Applicant's Responses to Deadline 6 Submissions

The West Midlands Rail Freight Interchange Order 201X

THE WEST MIDLANDS RAIL FREIGHT INTERCHANGE ORDER 201X
APPLICANT'S RESPONSES TO DEADLINE 6 SUBMISSIONS - DOCUMENT 17.1

Transport Technical Note 45 – Response to Connect Technical Note 02.

TITLE
2015, AM PEAK HOUR (0800-0900),
ALL VEHICLE TRAFFIC FLOWS
Version 1, 31/05/2017

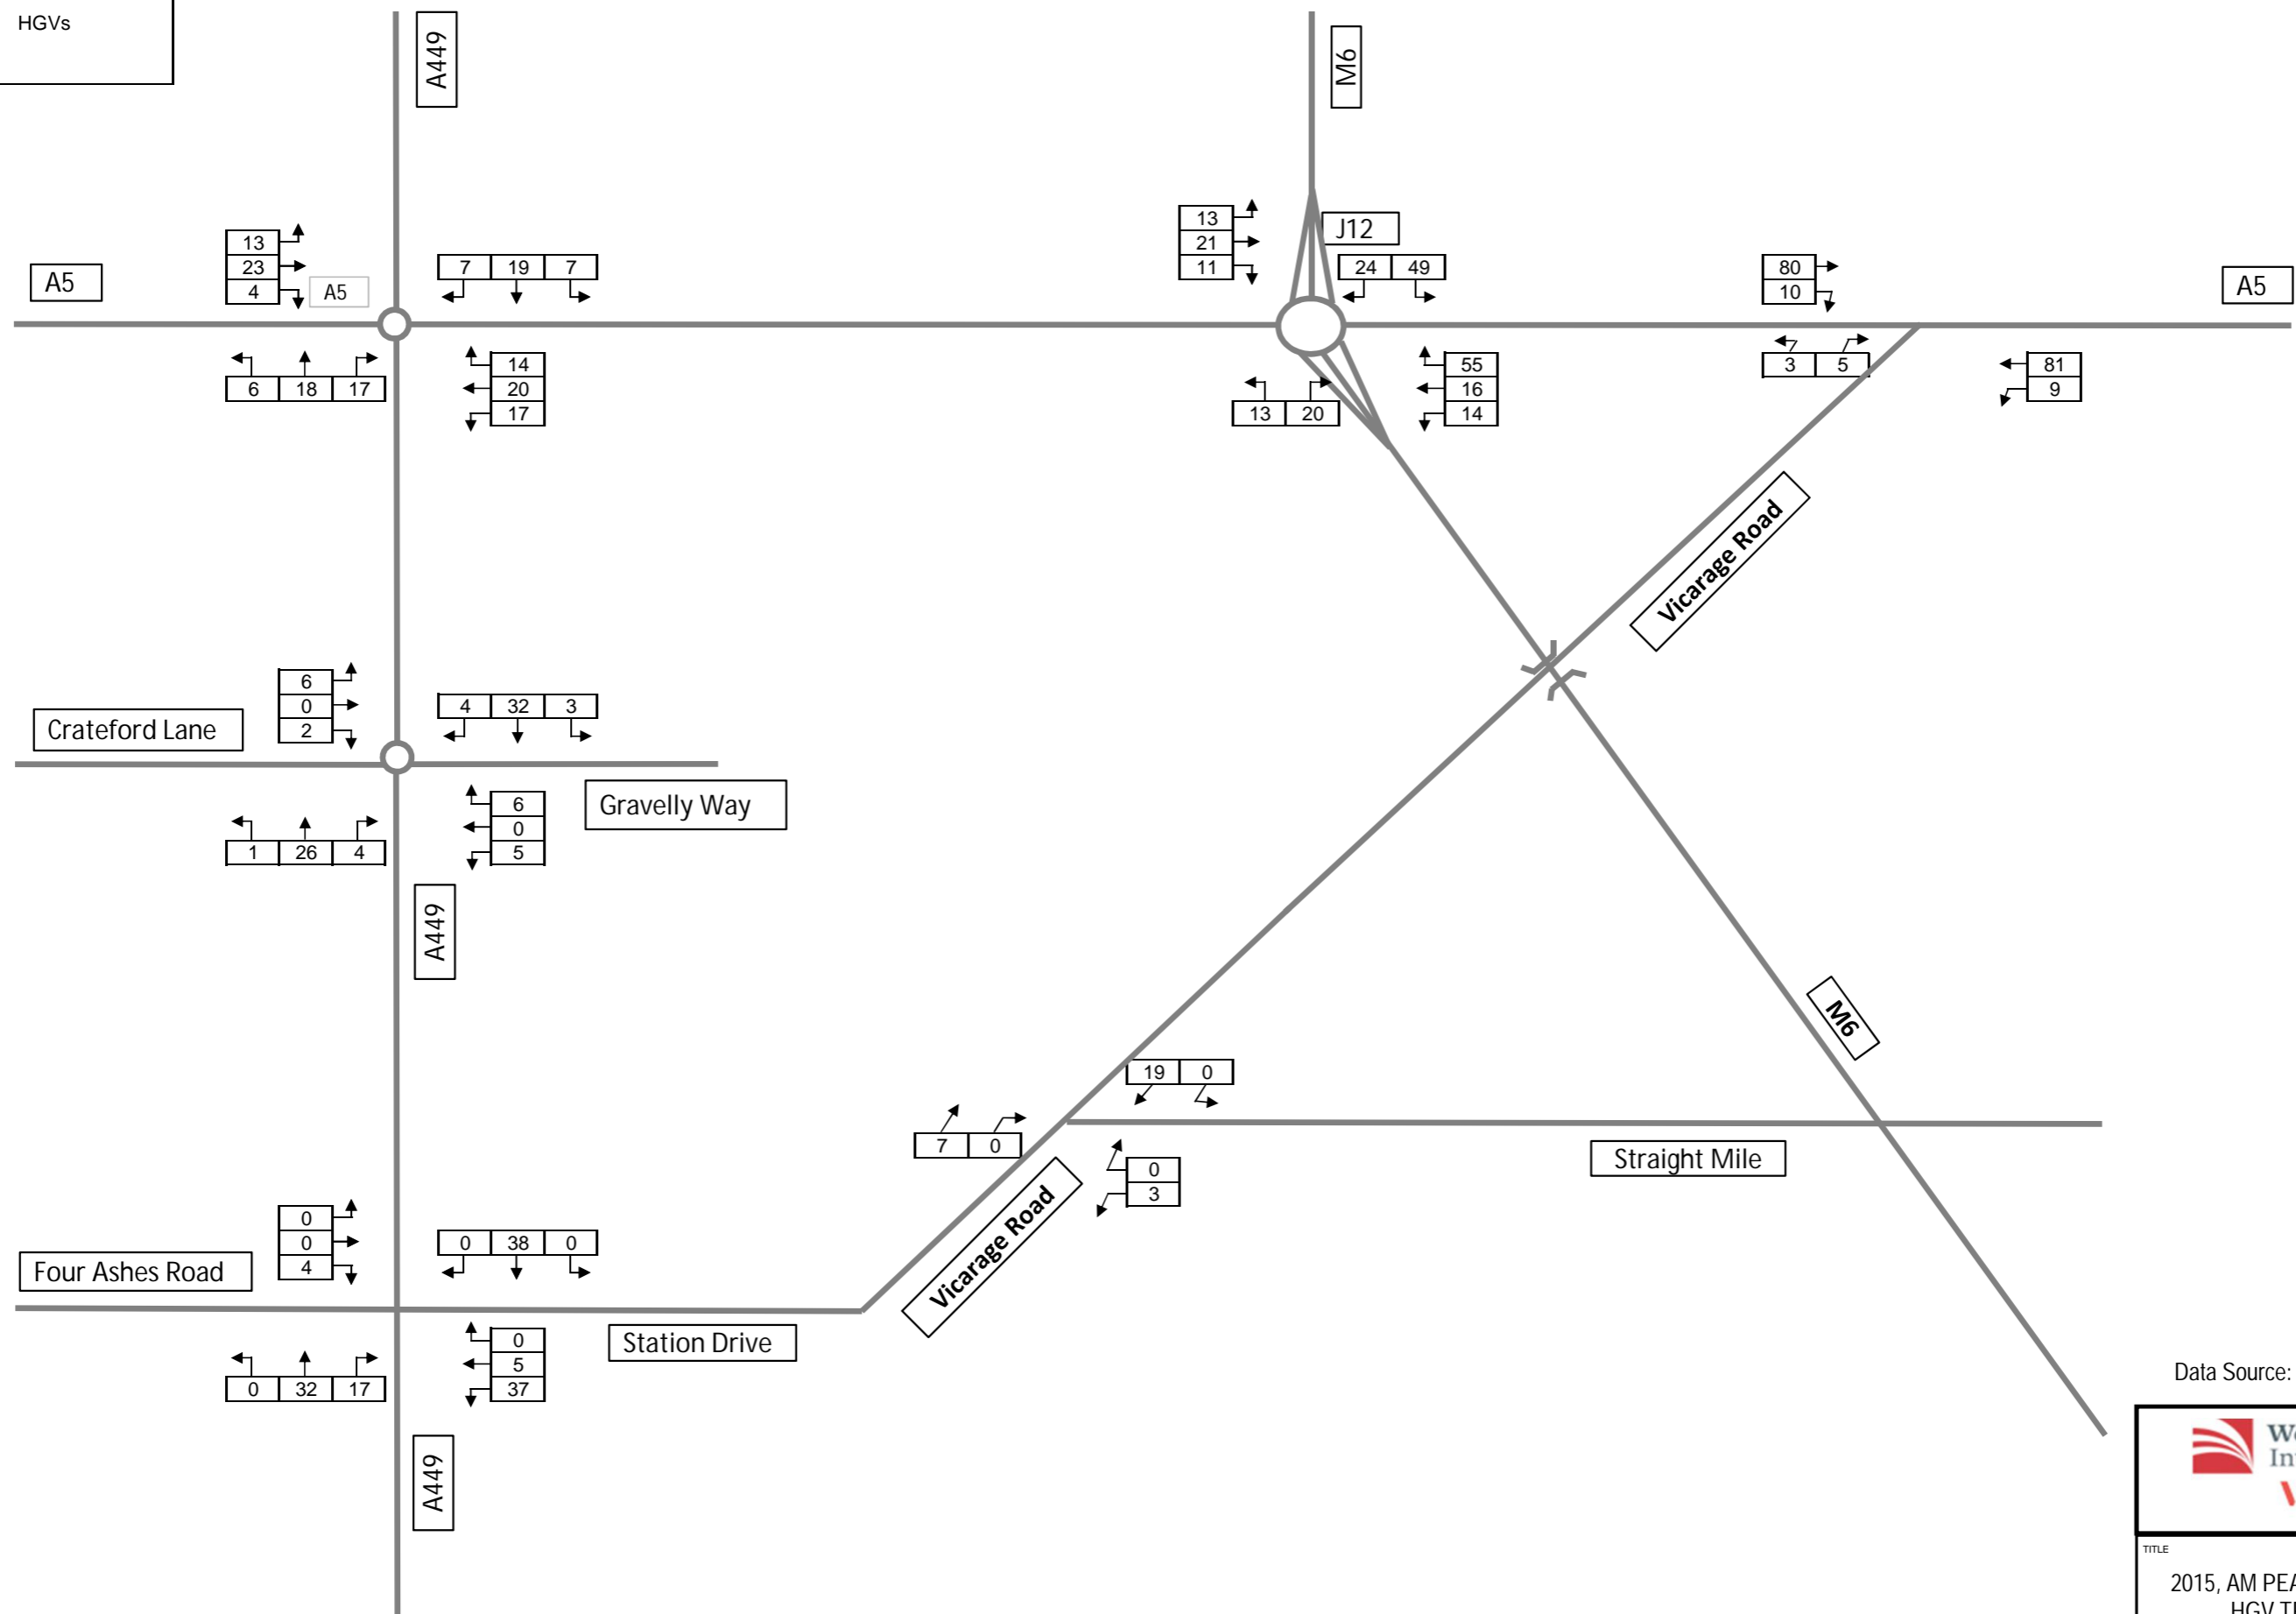
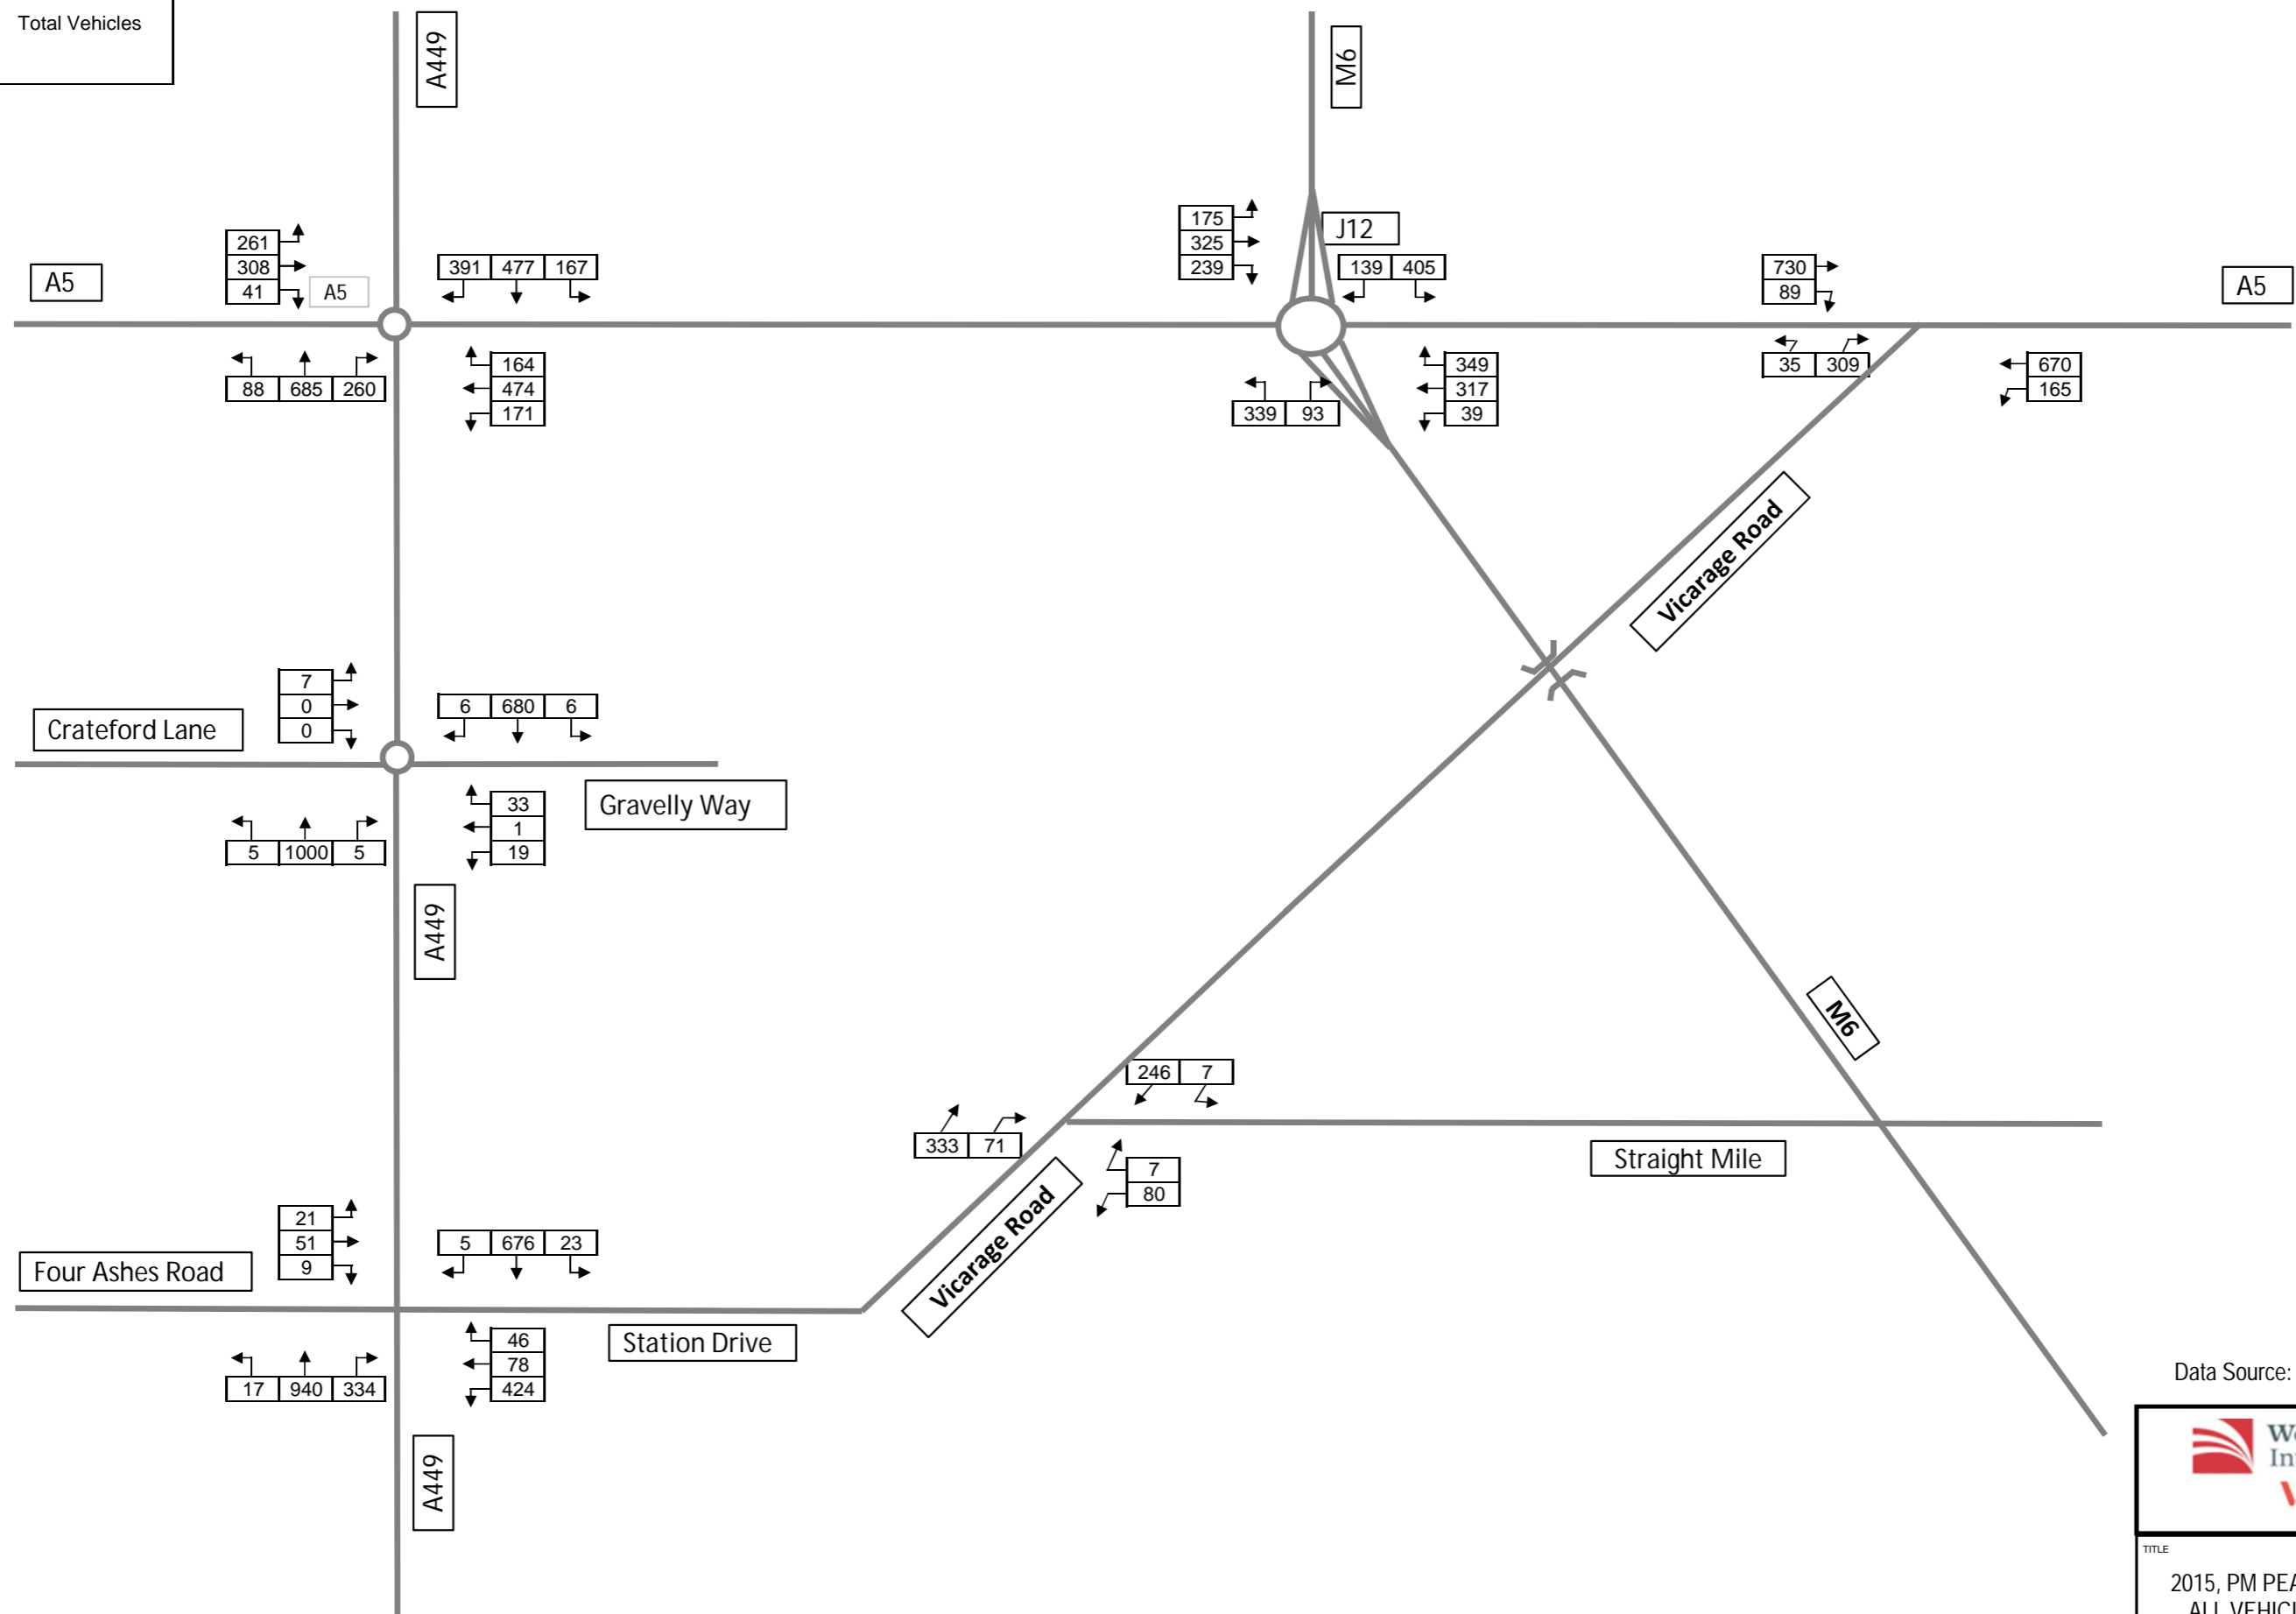
- 2.1 At paragraphs 2.5 – 2.8 of TN 02, Connect assert that there are errors in the traffic flow diagrams (APP-146) submitted with the application and call into question the reliability of the analysis. The specific issue they are referring to relates to the absence of U-turning traffic at the A449 site access roundabout in traffic flow diagrams (APP-146) included in the Transport Assessment (APP-114). WSP acknowledge that the specific U-turn movement from A449 south to A449 south is not shown on the traffic flow diagram at the A449 site access roundabout, however, the changes in traffic flows at the A449 / Station Drive junction to the south, as a result of the U-turning traffic, is included on the diagrams.

- 2.2 The junction turning movements provided to us by the VISSIM modellers (Systra) did not report the U-turn movements at any junctions, however, these u-turning traffic movements are modelled and included

2.3 Therefore, the Applicant can confirm that the traffic flows assessed and all analysis presented is correct and there are no errors. This position has been accepted by both Highways England and Staffordshire County Council.
